Recommendation Report for Planning Permission for Works or Extension to a Dwelling

REF NO: FP/19/20/HH

LOCATION: 18 Hinde Road
Felpham
PO22 7QJ

PROPOSAL: Proposed single storey rear and side extension with demolitions to rear.

18 Hinde Road, Felpham for Mr & Mrs L Purvey	
010 – Proposed Plans	
1:100 • A3	Jan 2020

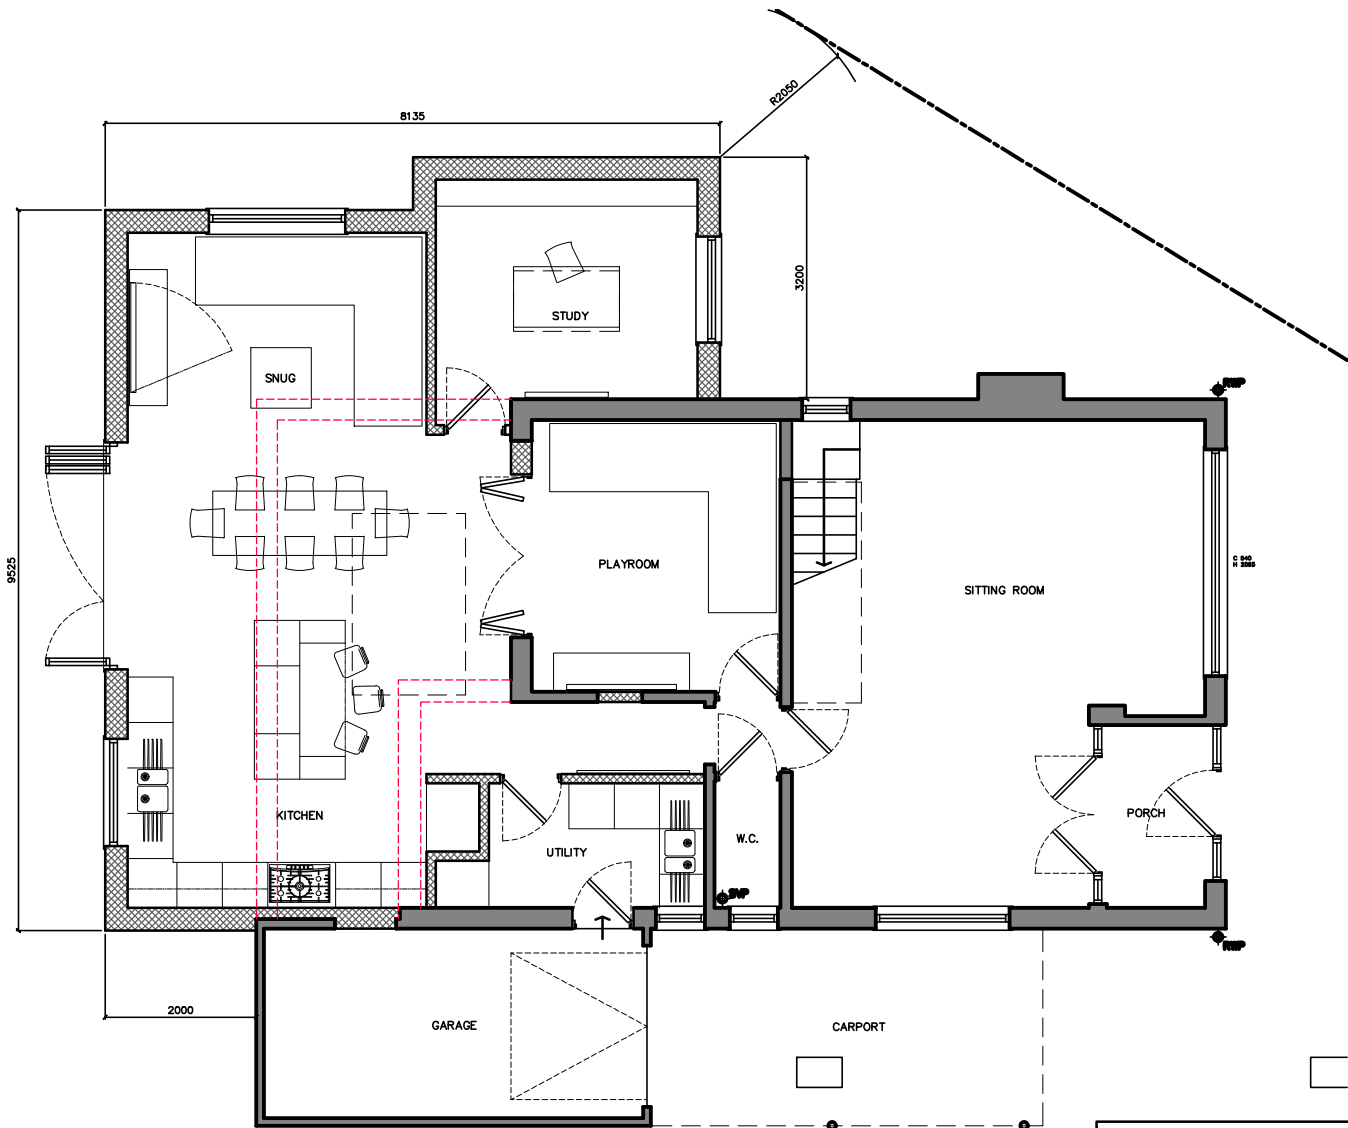
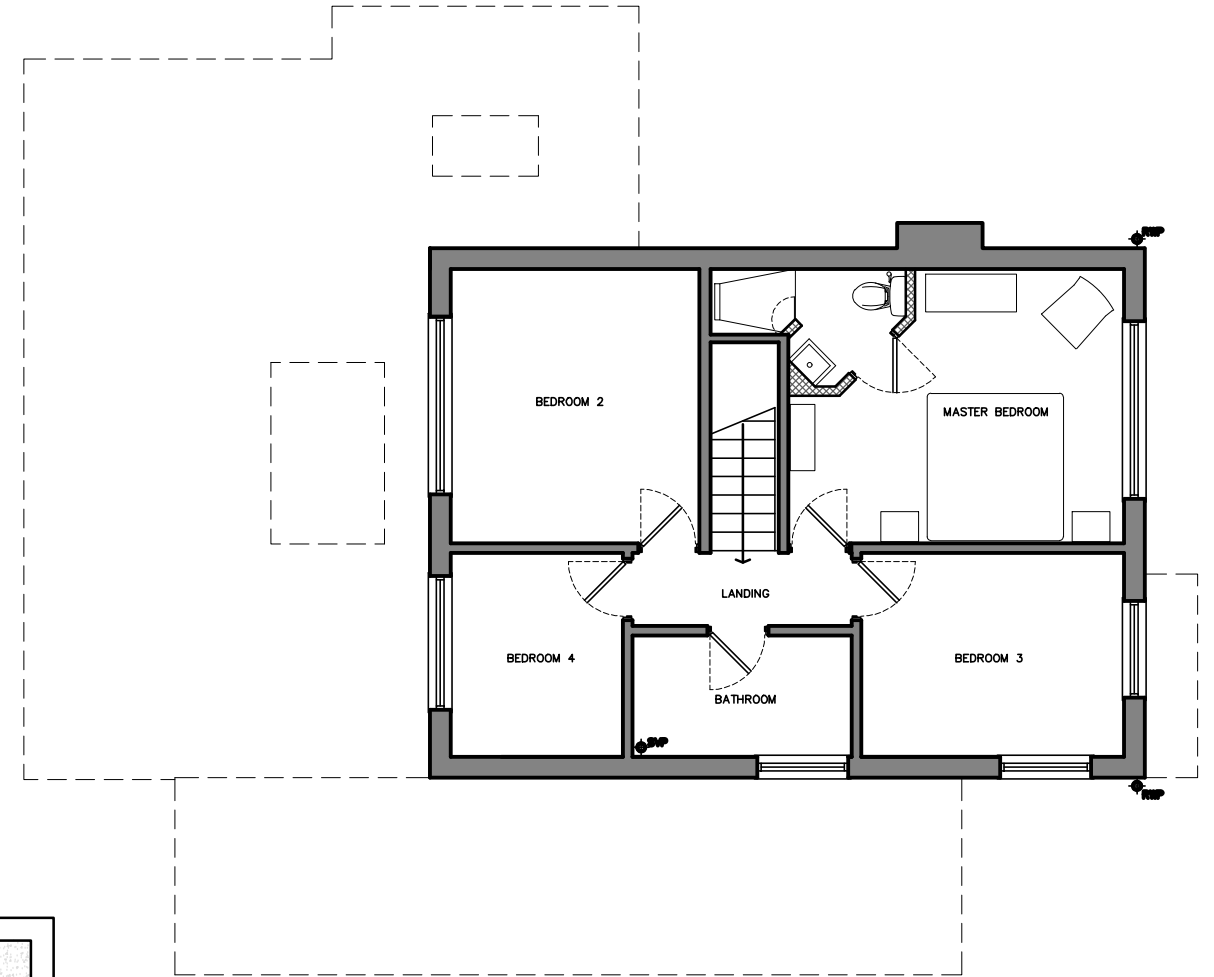
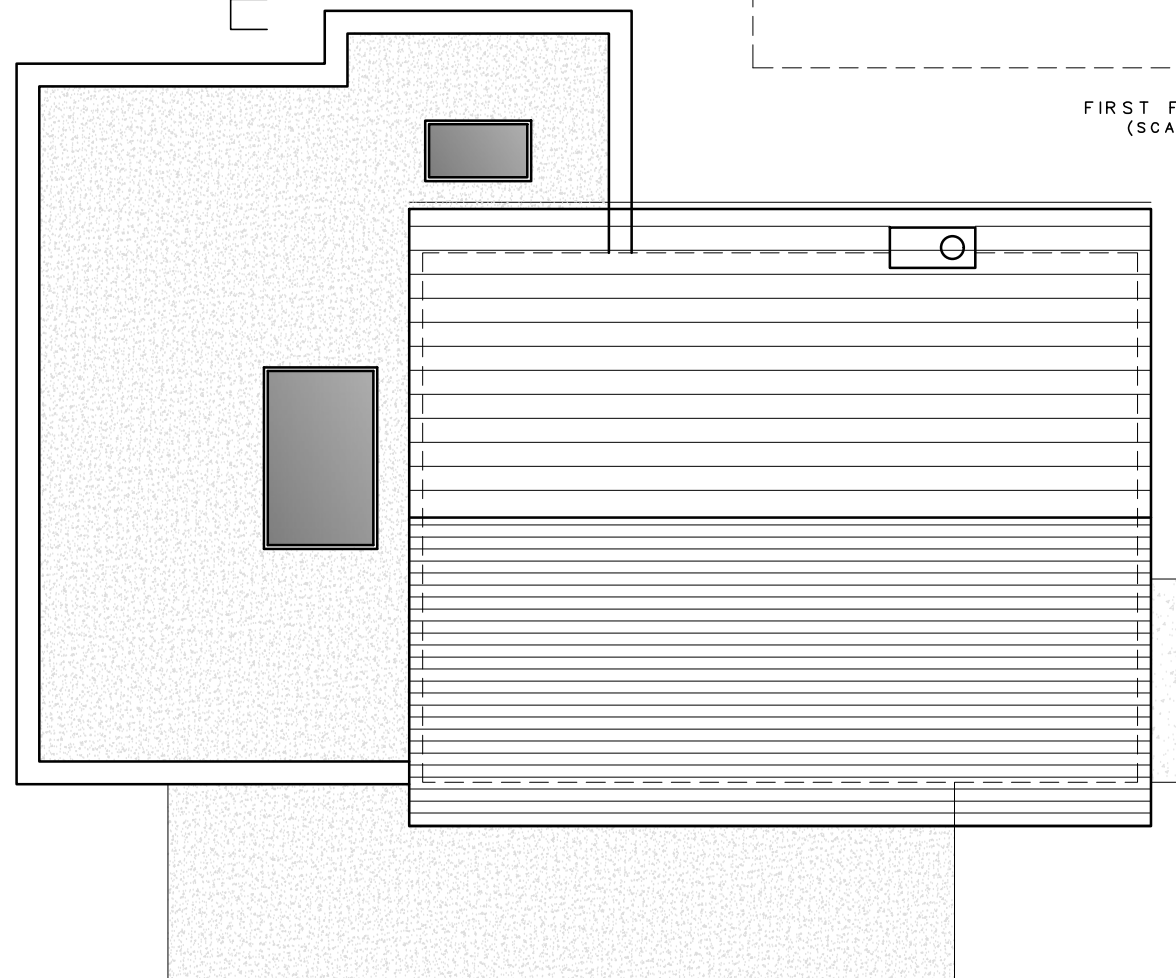
The proposed extensions will run along the rear of the property and extend beyond the side elevation by approximately 3.2m. There is an existing rear addition however this will be demolished.

The side extension will have a depth of around 2.85m extending along the north western elevation and a height of 3.2m. Due to the siting of the dwelling and side addition, a minimum of 2m is retained to the north western boundary and as such is not considered to result in an overbearing or overshadowing appearance.

011 – Proposed Elevations

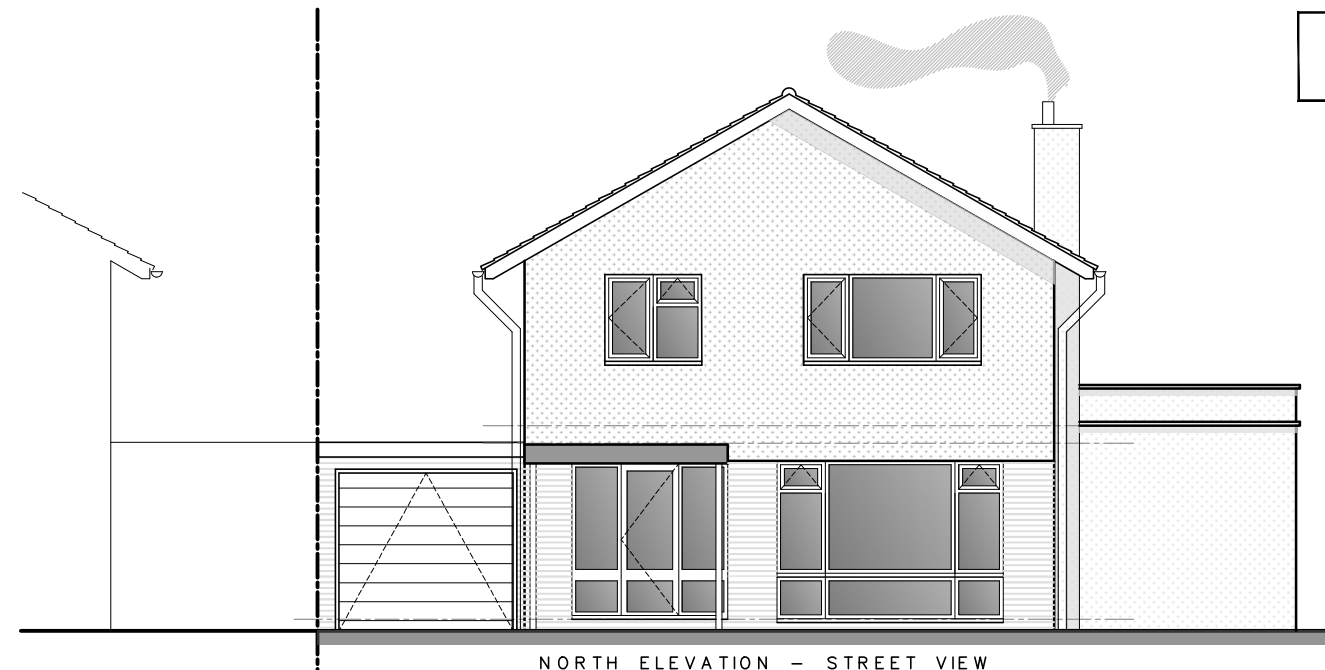
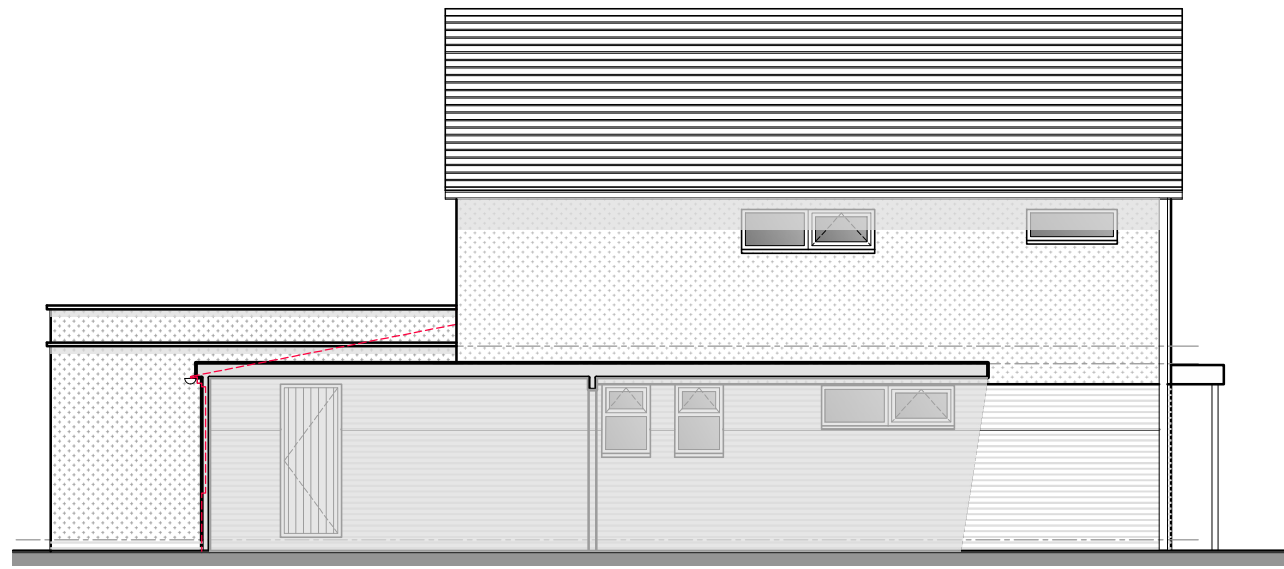
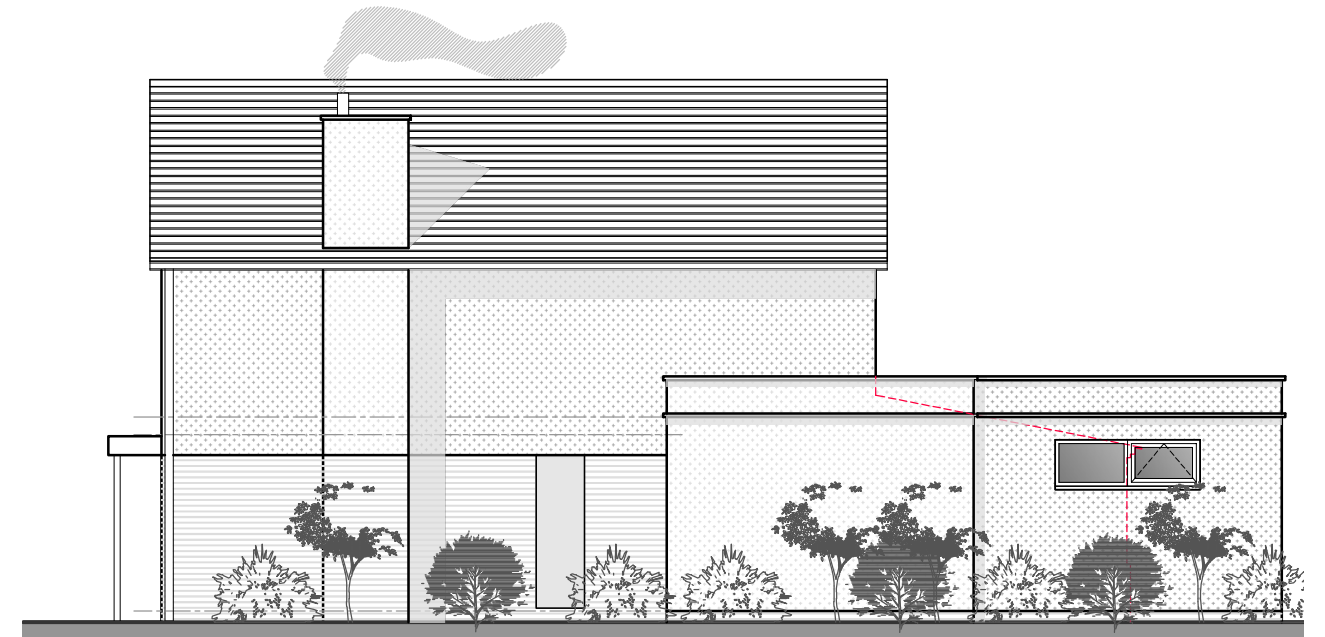
The extension will form an L shape running along the rear and wrapping around to the north-west elevation. The side extension will have a flat roof with a height of 3.2m. This element will face the street scene and appears large when compared to the attached garage to the eastern side. The extension does however retain 6.85m to the principal elevation and therefore is not considered to appear unduly dominant. A further 14m is retained to the front boundary of the property.

The rear extension will have a depth of around 5.1m. This is approximately 2m further than the existing addition that is to be removed. It will have a height of 3.2m with a flat roof. The rear extension does extend slightly beyond the neighbouring property at No.20 however with 2.5m retained to the boundary, the development is not considered to appear overbearing or overshadowing.

There will be glazed doors to the rear elevation of the extension. With the development at single storey and with sufficient boundary treatment in place, views are not considered additional to that which are already achievable.

There is an additional window proposed to the side extension however again due to the siting and with sufficient boundary treatment it is not considered to give rise to adverse views.
